Application No: BN/114/21/PL

Site Address: Land to rear of Highground House & Orchard End, Highground Lane
Barnham

Description of Works: Creation of 1 No. 1.5 storey dwelling on brownfield (previous use commercial car parking / children's play area associated with holiday let business) (resubmission following BN/53/21/PL). This application is a Departure from the Development Plan & is in CIL Zone 3 & is CIL Liable as new dwelling.

PROPOSED ELEVATIONS 1:100 @A1

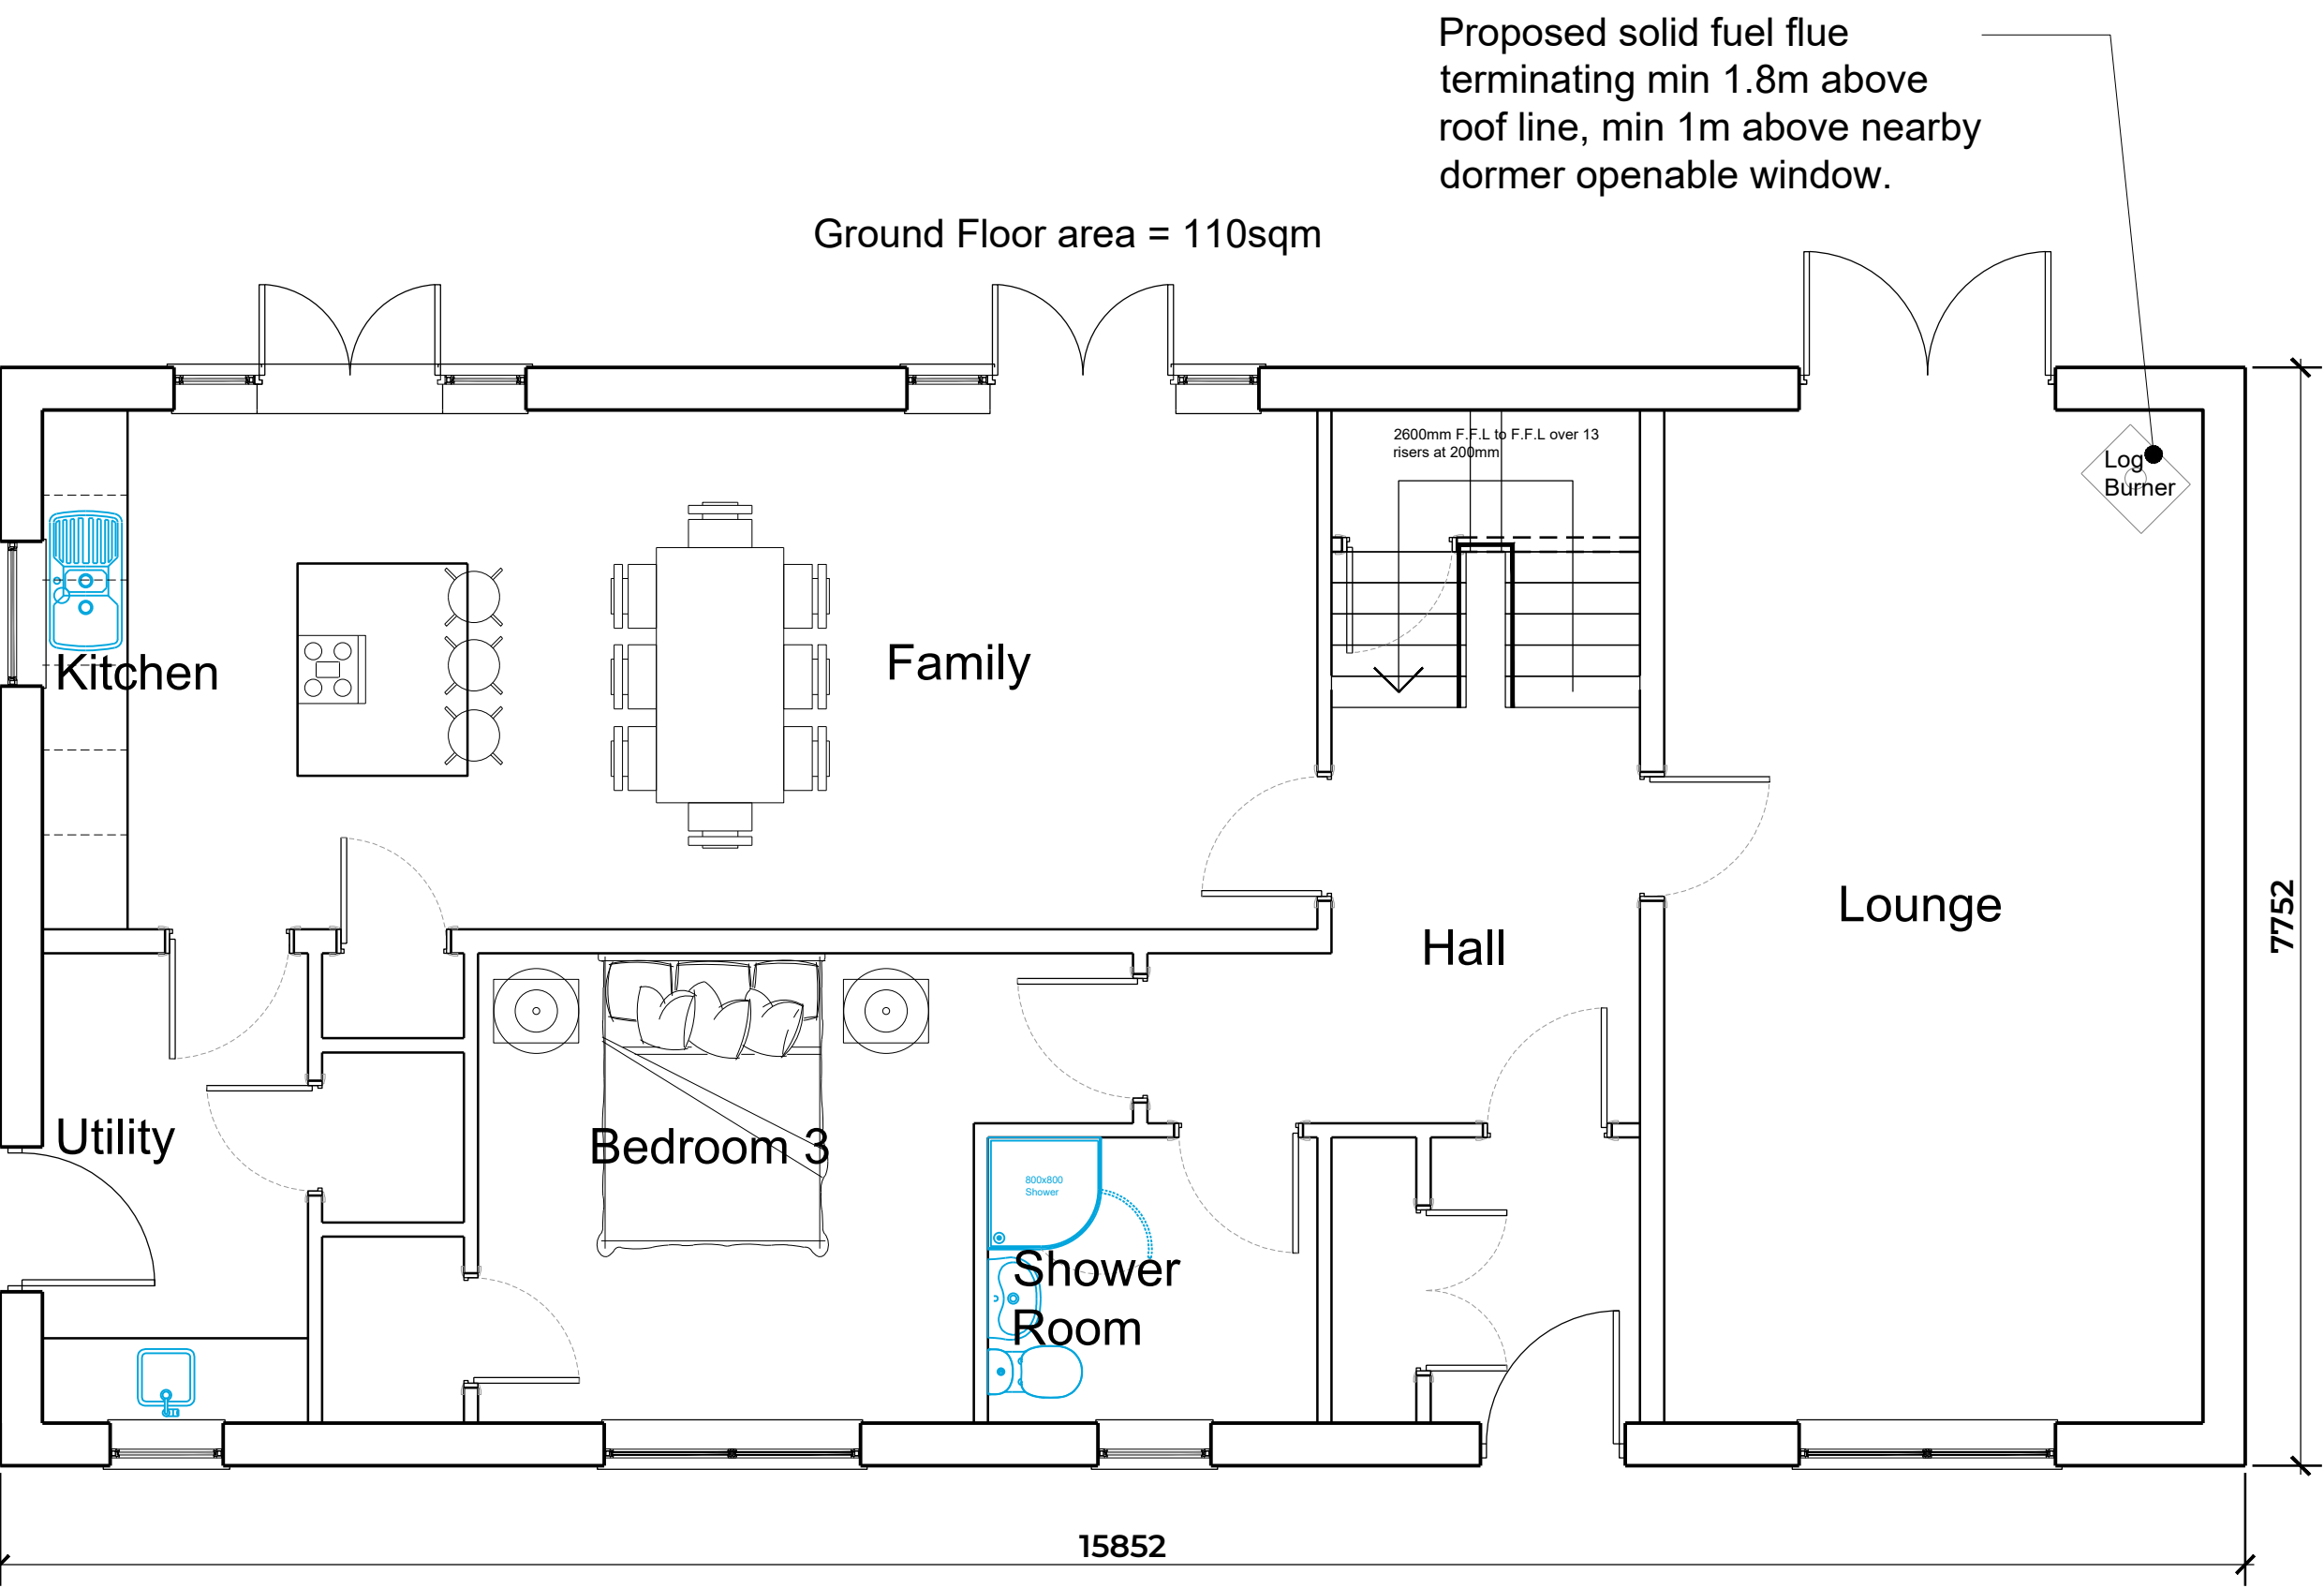
We require that a bat brick is integrated into the building onsite facing south/south westerly positioned 3-5m above ground.

We would like a bird box to be installed on the house / and or tree within the garden of the property.
